Observations By:	KC, Highways Development Management
Application No.	2020/90805
Proposed Development:	Reserved matters application pursuant to outline permission 2015/90430 for erection of residential development comprising (Use Class C3) and incorporating associated new access (to Crossley Lane and Cold Royd Lane), and associated works (126 dwellings)
Location:	Land to North and South of, Crossley Lane, Dalton, Huddersfield, HD5 0QP
OS Map Reference	SE 417425.5056417339.3308
Applicant/Agent:	JRP
Class:	Small Major Developments

Consultation Response from KC, Highways Development Management		
2020/90805 Land to North and South of, Crossley Lane, Dalton, Huddersfield, HD5 0QP		
Reserved matters application pursuant to outline permission 2015/90430 for erection of residential development comprising (Use Class C3) and incorporating associated new access (to Crossley Lane and Cold Royd Lane), and associated works (126 dwellings)		
Date Responded:01/07/2020	Responding Officer: Mark Berry	Responding Ref: 11-8SW-1

Proposed Traffic Calming Scheme

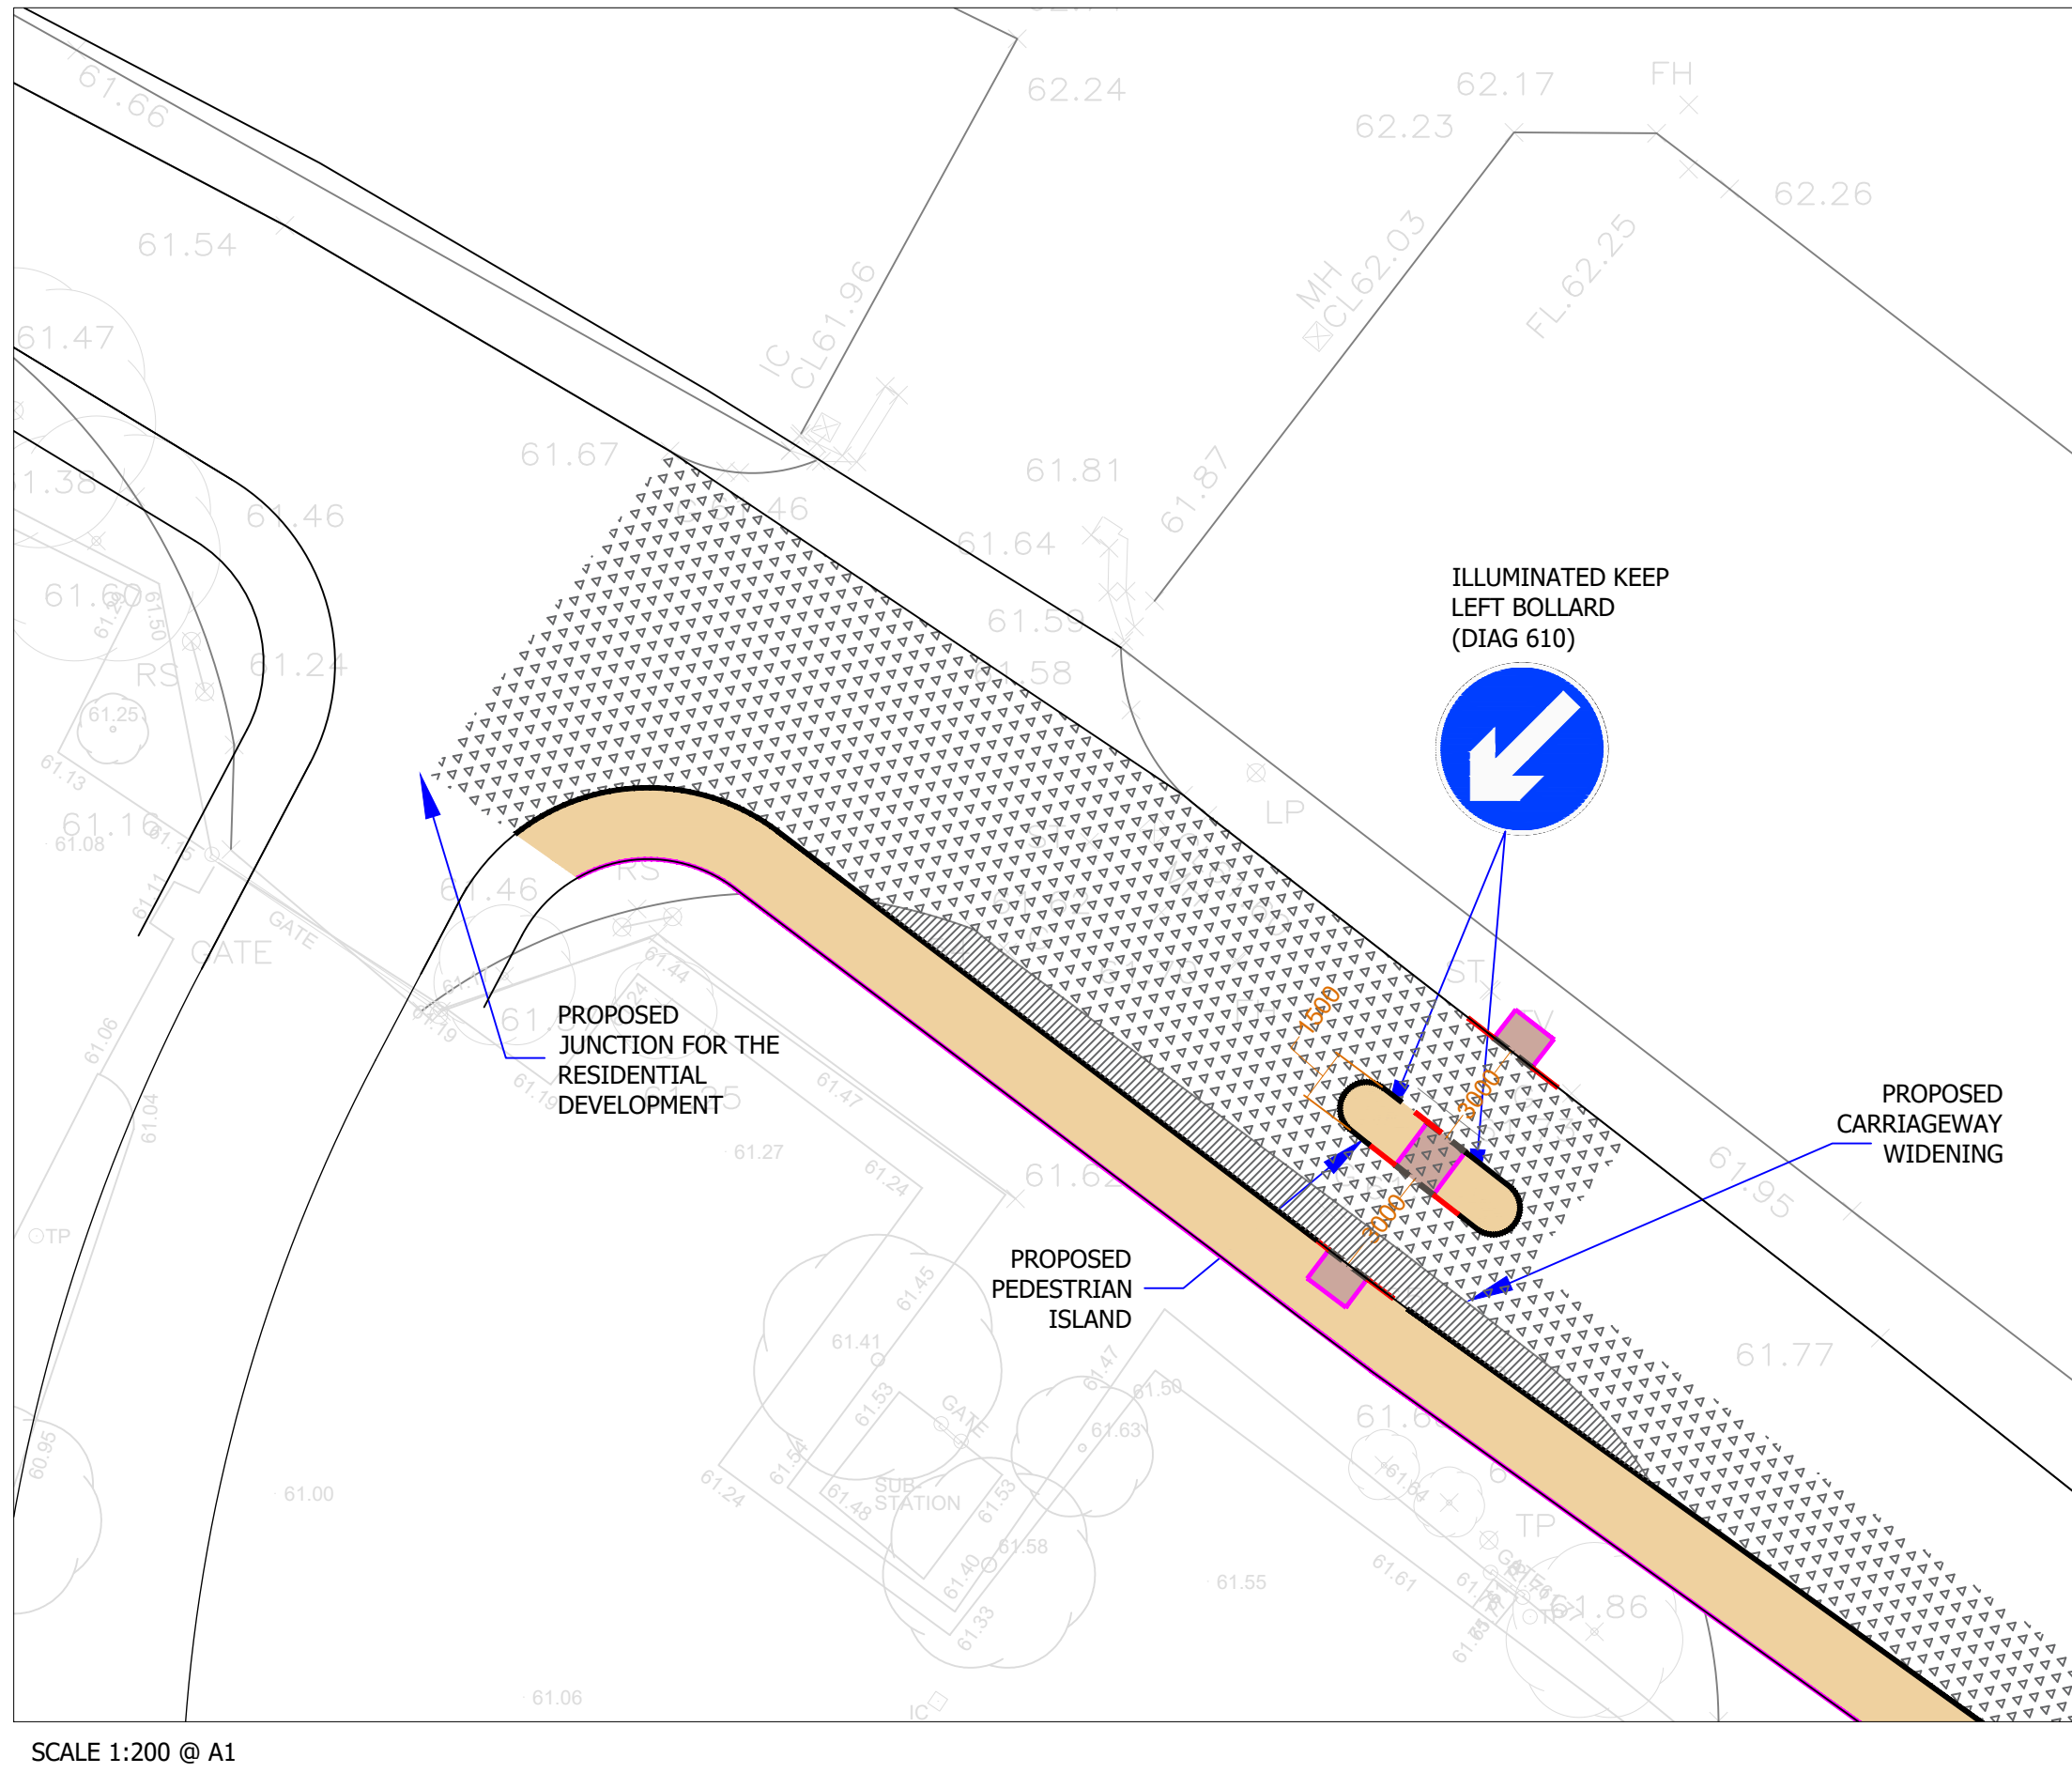
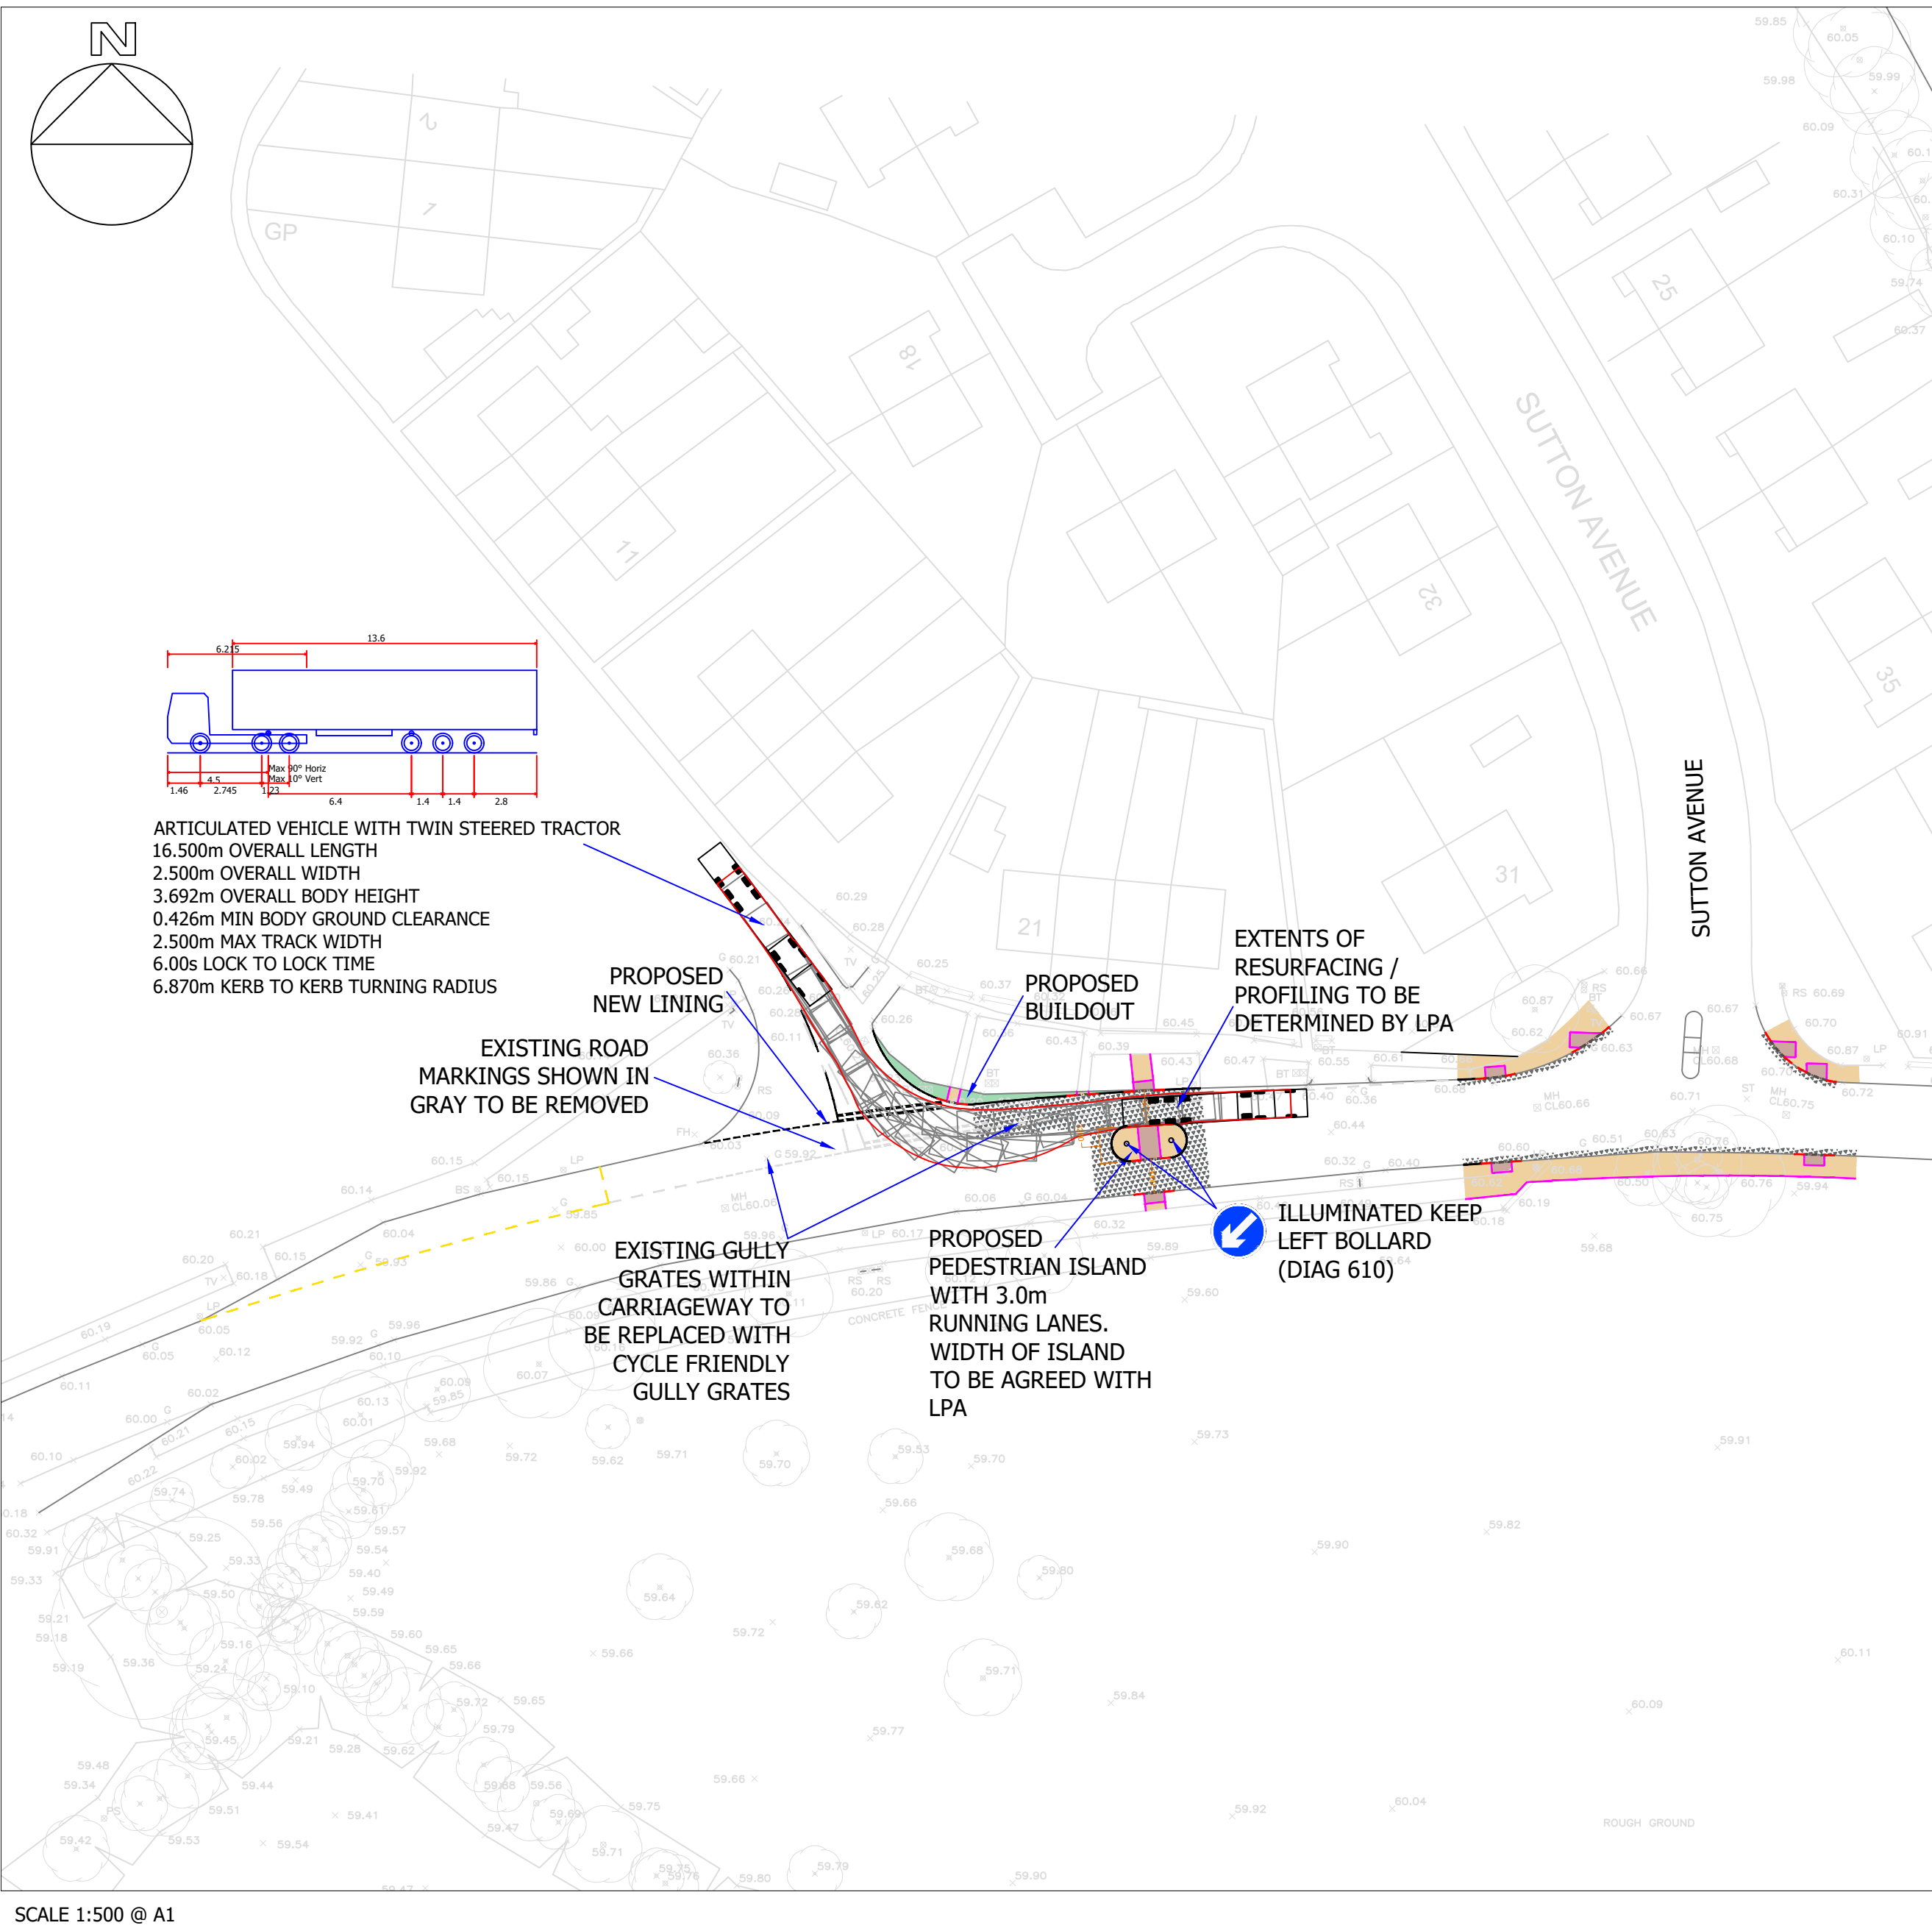
The Councils Highway safety team have concerns regarding the proposed traffic calming scheme which dates to October 2010. Traffic calming should not be used to accommodate sub-standard access arrangements, particularly on a relatively major route such as Crossley Lane. Such measures should be employed at sites with a history of speed-related injury accidents, and there have been none recorded on this stretch of road in the last 5 years.

The plateaux indicated appear to greatly exceed the dimensions set out in our Standard Details, which specify a maximum plateau length of 10m (plus ramps) and may also not be suitable for use on a bus route.

Highway Safety would recommend that other mitigation measures are provided and direct frontage access onto Crossley Lane is minimised.

The raised traffic calming plateaus need to be removed from within the site. These are not considered necessary.
